Application for a non-material amendment following a grant of planning permission.

Residential development comprising 34 dwellings at land Off Small Drove Weston Spalding

Reference number:	H22-0843-19
Date of decision

Adjustments to proposed boundaries.

Drawn by	Checked	Date	Scale
PC		FEB 2018	1:200@A1
SITE PLAN			
Dwg No	Rev		
J1651 (08) 03	C

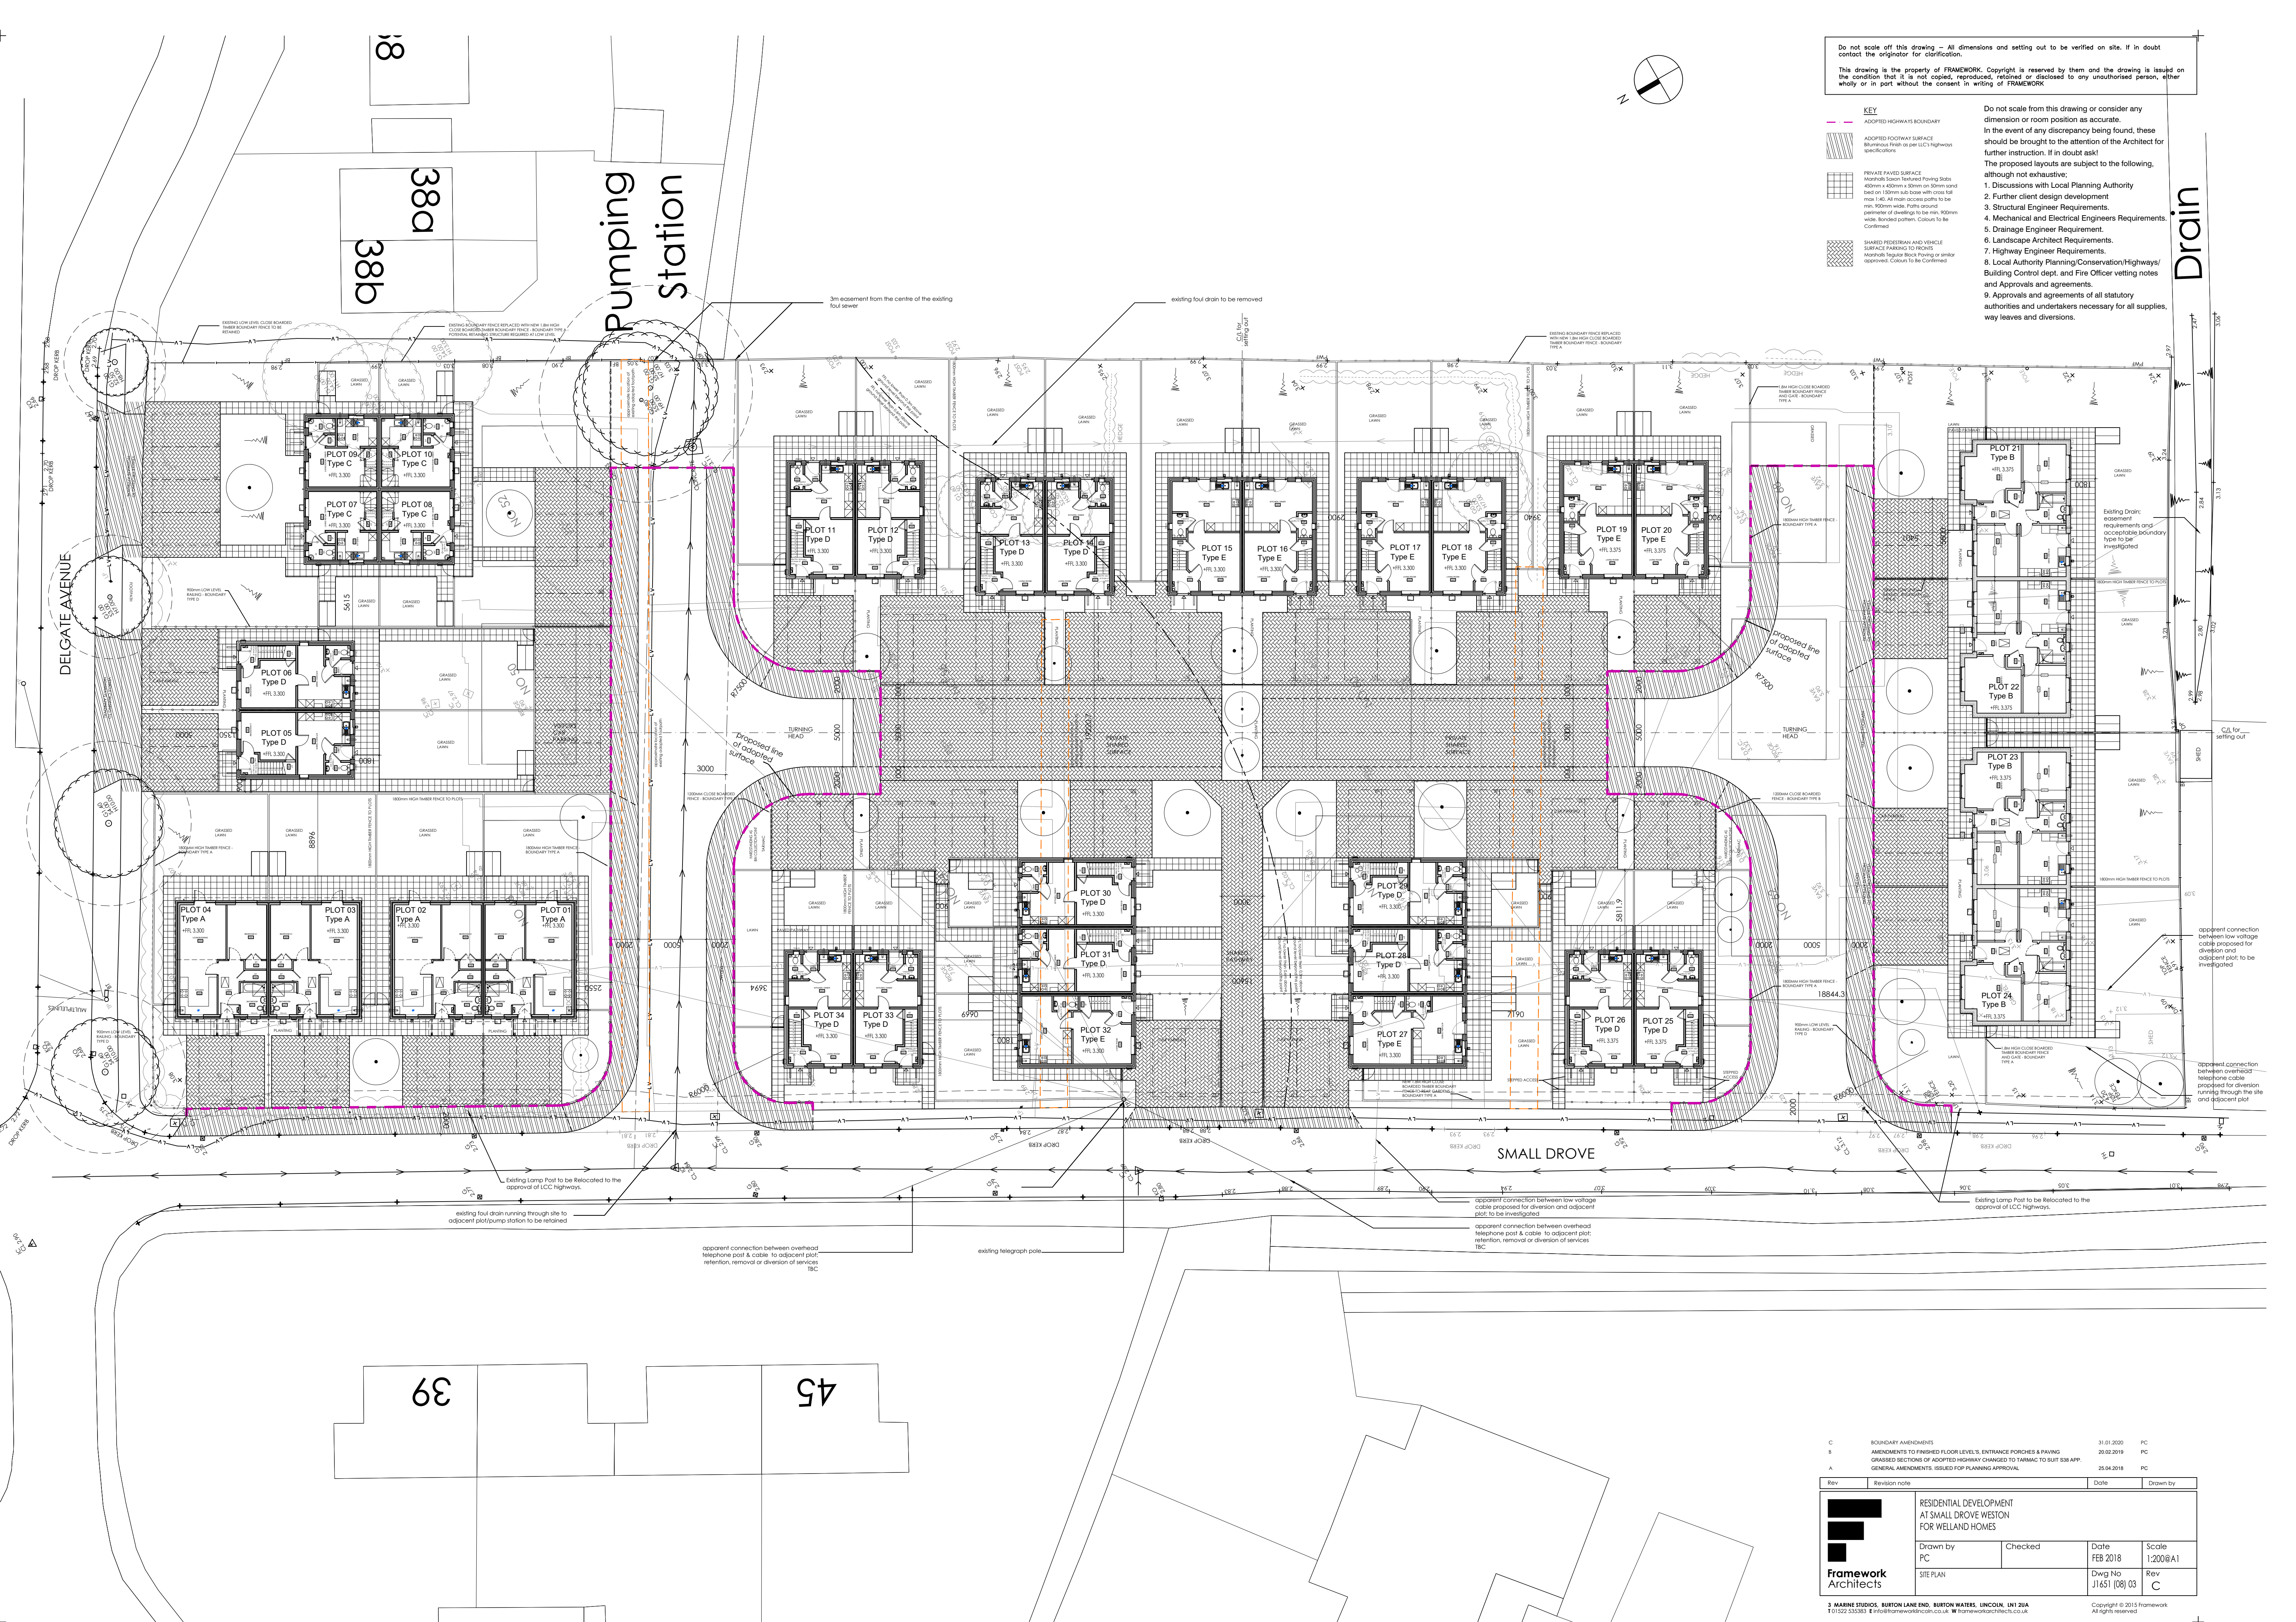
Due to ground bearing issues we have omitted the brick type boundary walls.
The 1800 high wall has been replaced with a 1.8m high fence and the low level brick wall has been replaced with a 1.2m high fence with concrete gravel boards. The hedge shown as retained along Delgate Avenue has been replaced with a 1.8m closeboard fence with black railings to the frontage to match the other plots along Small Drove.
